MIRVAC

AUSTRALIAN TECHNOLOGY PARK
- BUILDING 1
- BUILDING 2
- COMMUNITY BUILDING
- PUBLIC DOMAIN

ACCESS REVIEW

10th December 2015

TOTAL CAR SPACES:
Lower Ground (93 spaces) + Mezzanine (60 spaces) + Upper Ground (64 spaces) = 217 car spaces

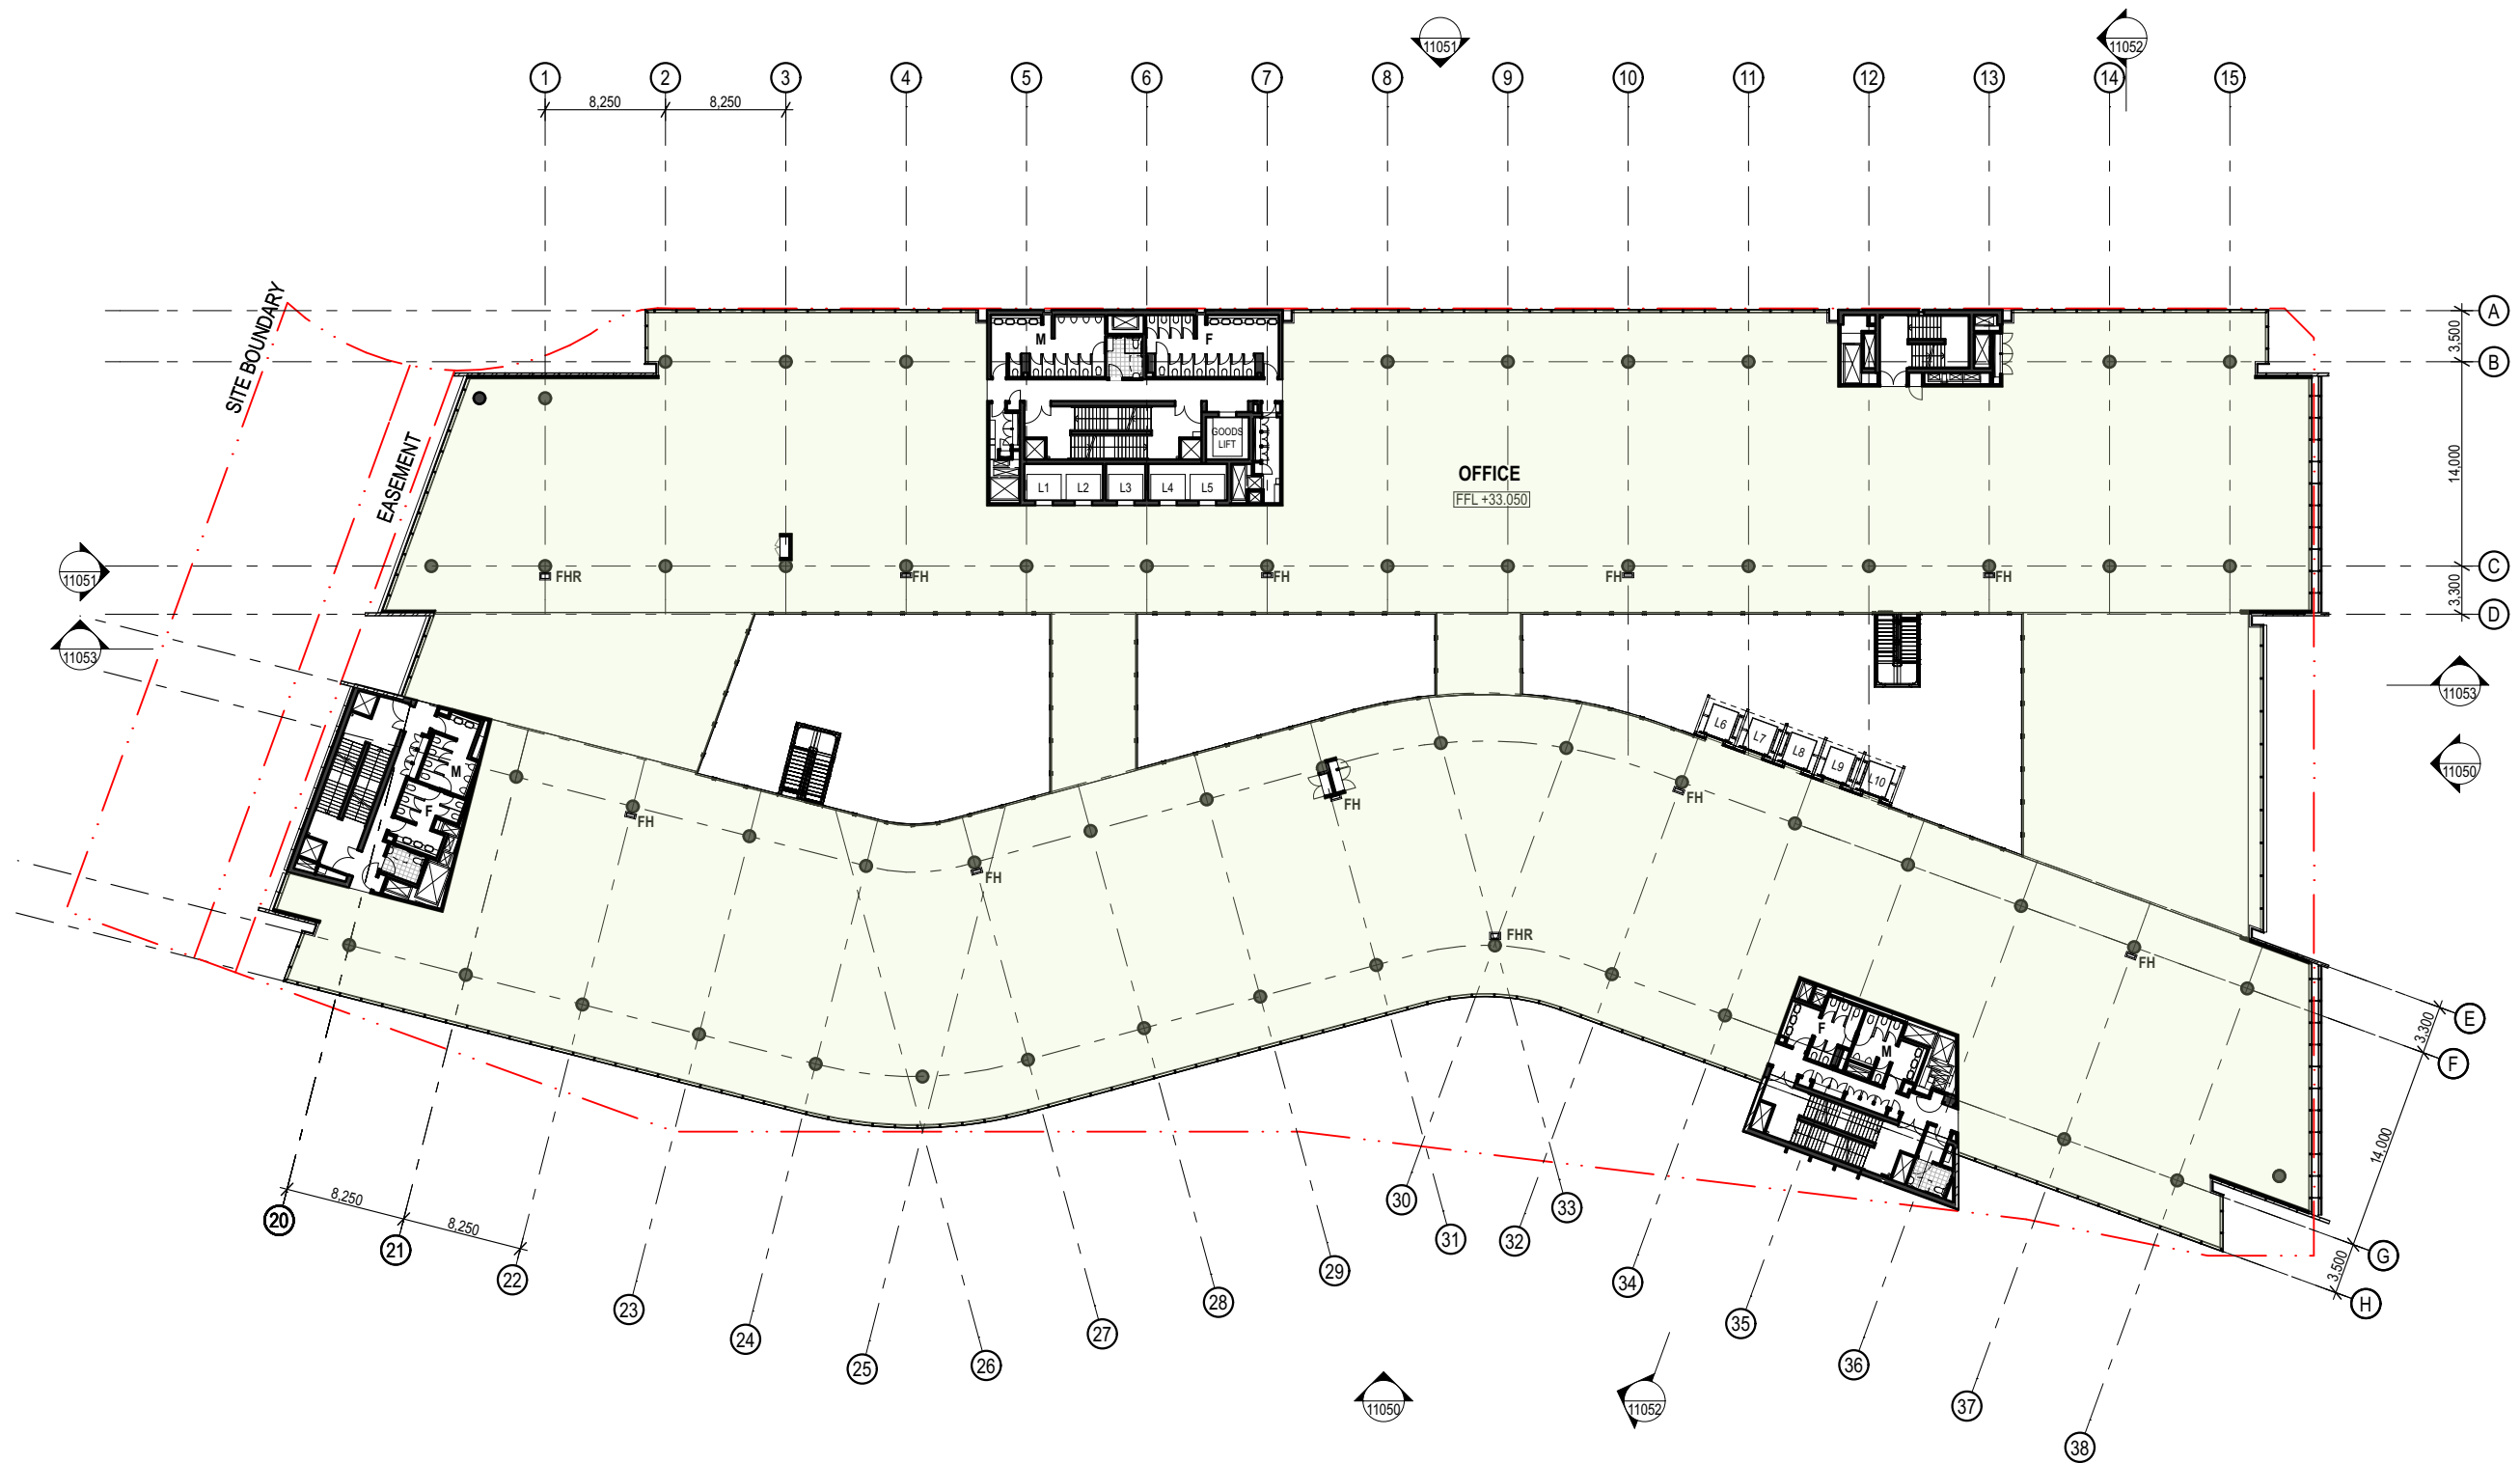
However, the accessible path of travel from the accessible car bays located on the floor ground floor level to the entry point of the End of Trip Facilities will need to be provided with turning circles, 1540mm in width for a minimum length of 2070mm, for compliance under AS1428.1:2009. This is due to the current corridor having a length greater than 20m and a width of only 1500mm.

However, the basin located within the right hand transfer accessible toilet currently encroaches within the circulation space of the shower. This is due to the structural column located to the corner of the room.

Also, drawings indicate there to be a total of 17 right hand transfer pans and only 8 left hand transfer pans. As per the DDA Premises Standards, an even amount of left and right handed pans is required to fulfil compliance.

Car parking has been provided to the lower ground floor level, mezzanine level and upper ground floor level of the building, with a total of 217 car spaces. A total of 5 accessible parking bays have been provided to the lower ground floor level. The number of accessible parking bays satisfies the requirements of the DDA Premises Standards table D3.5.

- (i) Ensure flooring systems used comply with BCA and HB198/AS4586.
- (ii) Turning circle of no less than 1540mm wide x 2070mm length to be provided to the accessible path of travel leading from the accessible car bays to the entry point of the End of Trip Facilities on the lower ground floor level.

- (i) Ensure a clear circulation space about the shower recess to the ground floor accessible toilet of 1600mm x 2350mm, compliant with AS1428.1:2009.
- (ii) The public accessible toilets throughout shall have suitable pan locations that allow a mixture of left and right transfer pans, compliant with AS1428.1:2009 and the DDA Premises Standards.
- (iii) Ensure all bathroom fixtures comply with AS1428.1:2009.

- (i) Ensure the accessible car bay has a vertical clearance of 2.2m whilst travelling to the accessible car bay and 2.5m within the accessible car bay, compliant with AS2890.6.
- (ii) Ensure there is a safe and accessible path of travel to the lifts from the car bays. Consideration shall be given as to relocate the accessible parking bay closer to the lift lobby.
